CGS Unique No. EP-26-0066_2

Project Name: Pyramid Mountain

El Paso File Number: SF262

As requested (email dated April 6, 2026), the Colorado Geological Survey reviewed the resubmittal documents for the final plat for Pyramid Mountain in Cascade, Colorado. The documents include a Soils and Geology Study (Entech Engineering Inc., Revised April 1, 2026), Final Plat (Gould Land Surveying, Rev. March 25, 2026), Site Plan (RDK Design, (April 2, 2026), Preliminary Drainage Report (All Terrain Engineering, March 2026), and other documents. The site consists of one single-family lot within 16.9 acres. CGS previously reviewed the application for the final plat and provided comments dated February 16, 2026.

# PYRAMID MOUNTAIN FILING NO. 1

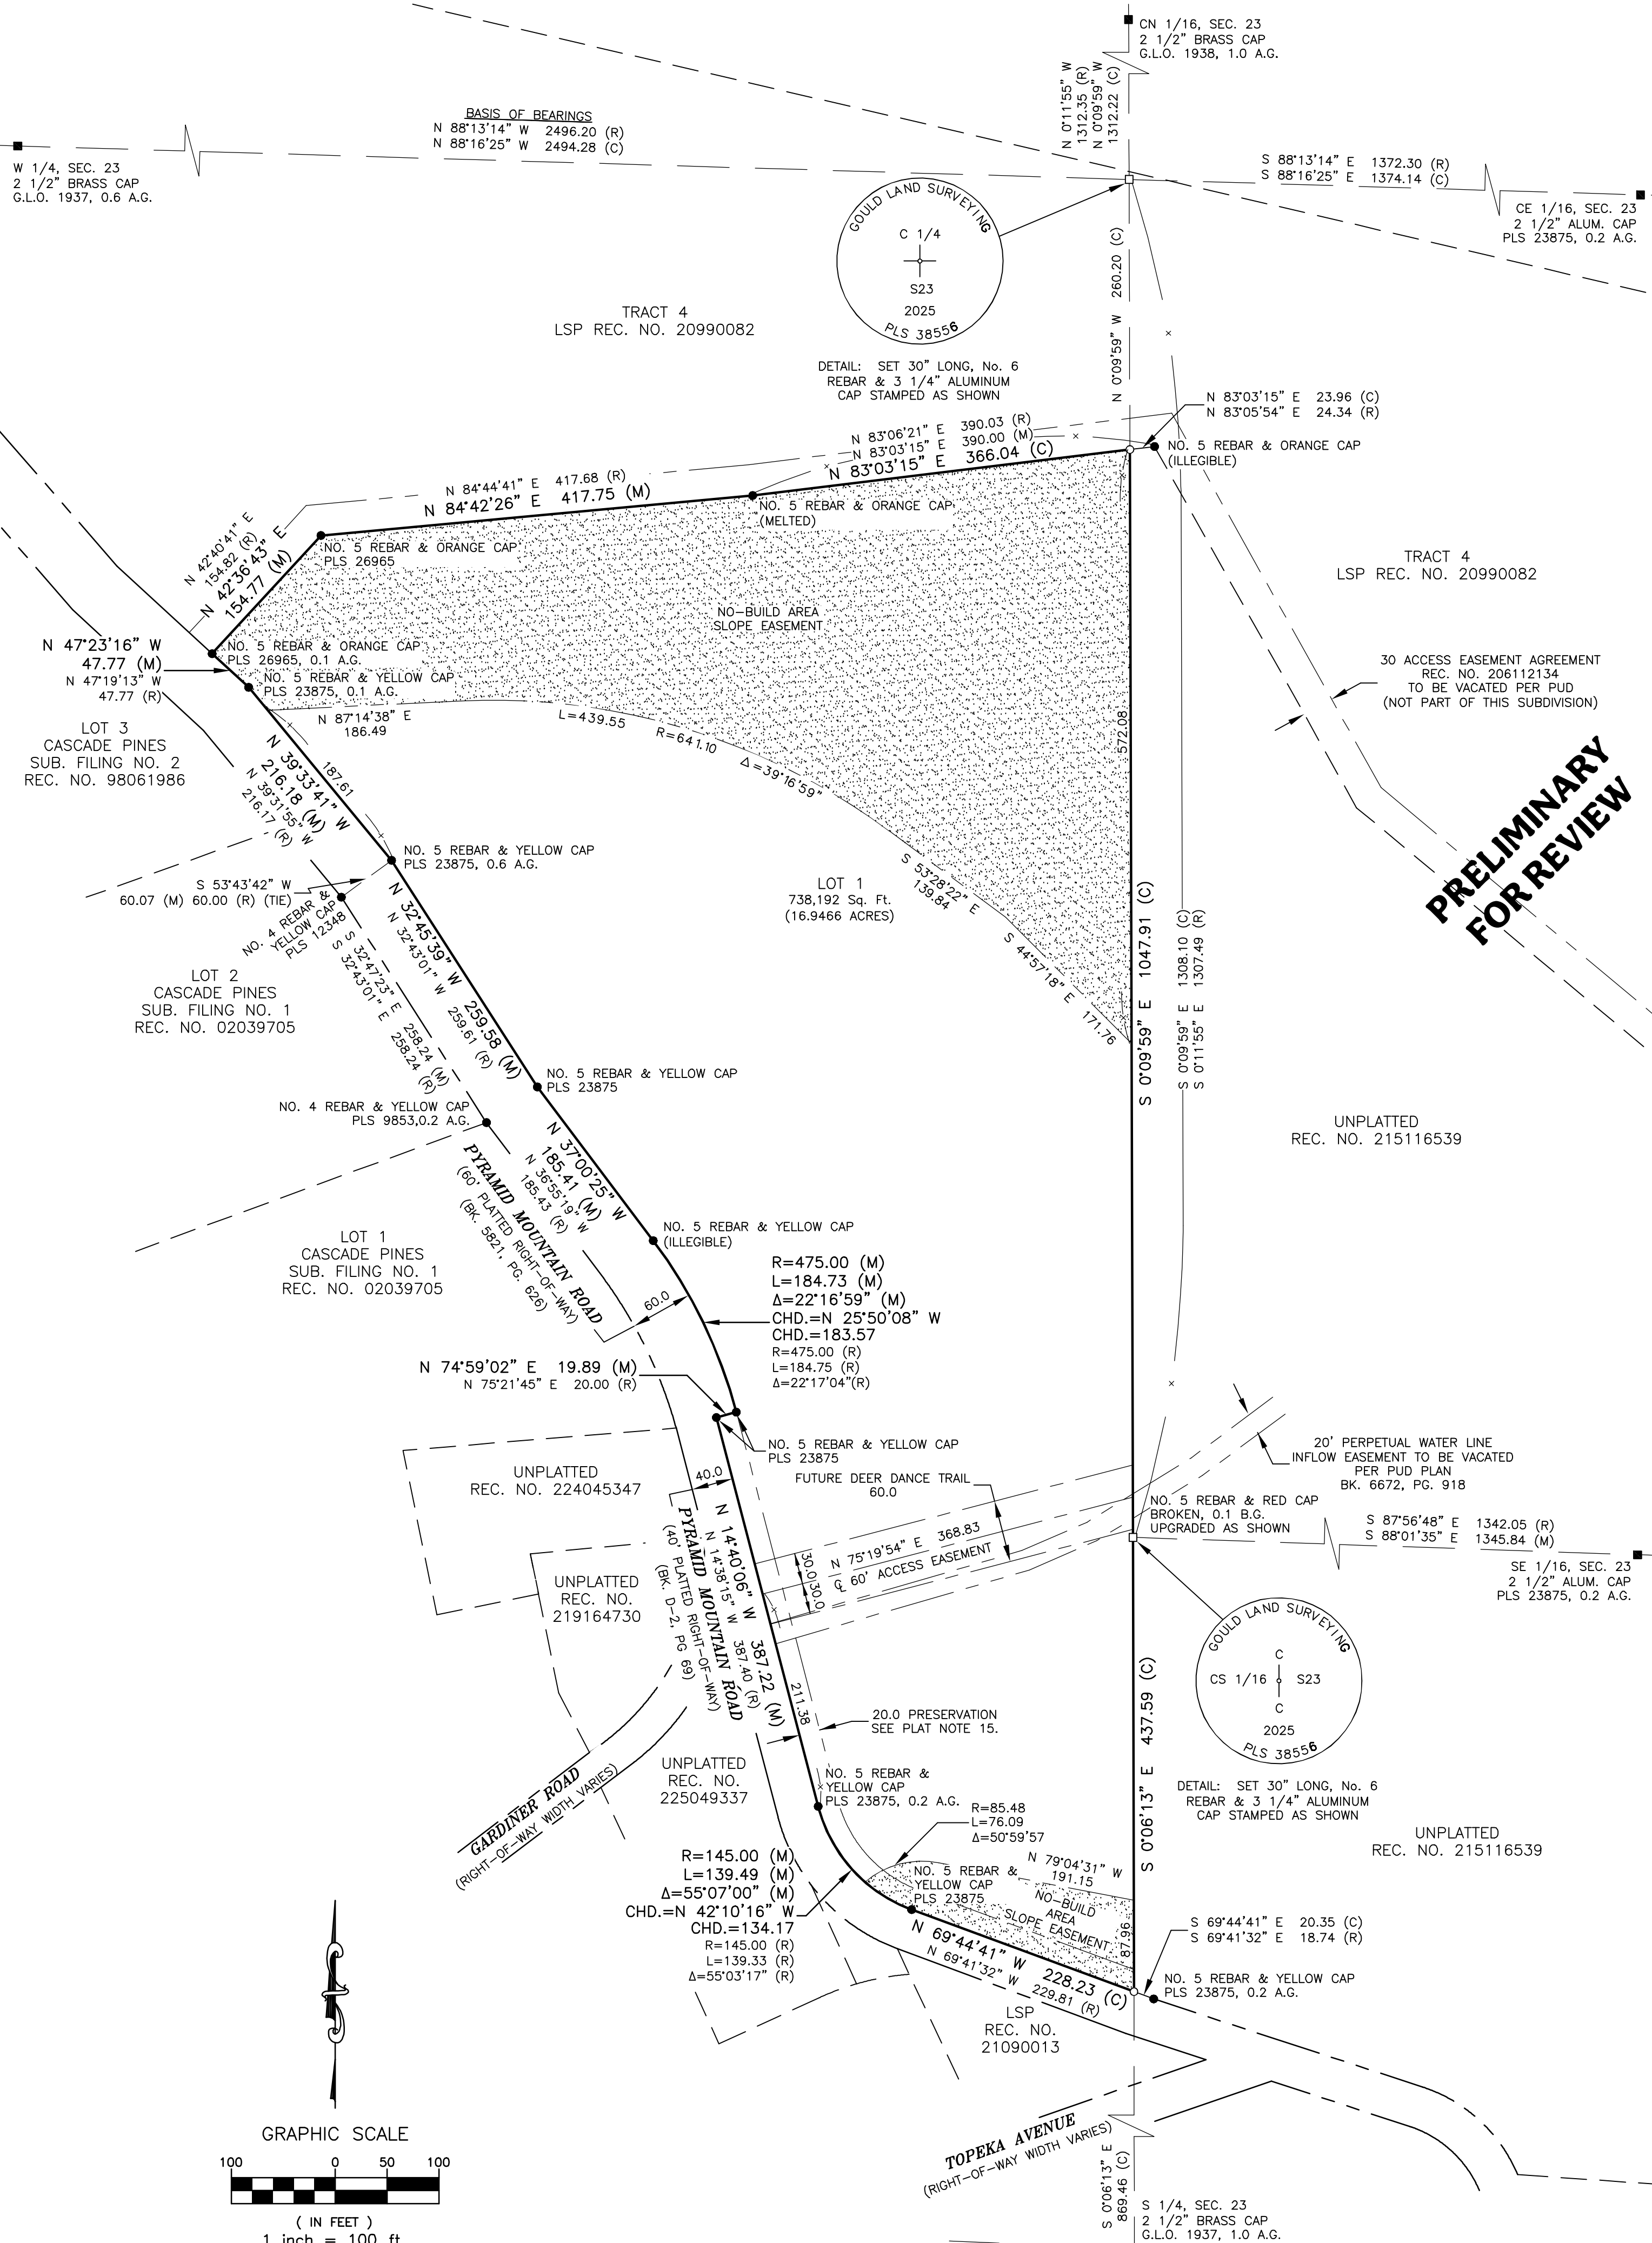
Geologic Hazard Note. CGS recommends that geologic hazards, constraints, and mitigation measures (if necessary) be included in the final plat/site plan in accordance with El Paso County's Land Development Code and the Engineering Criteria Manual. Hydrocompaction associated with unconsolidated alluvial fan deposits should also be included.

Entech's recommendations should be strictly adhered to during design and construction, and any mitigation measures should be noted in the final plat.
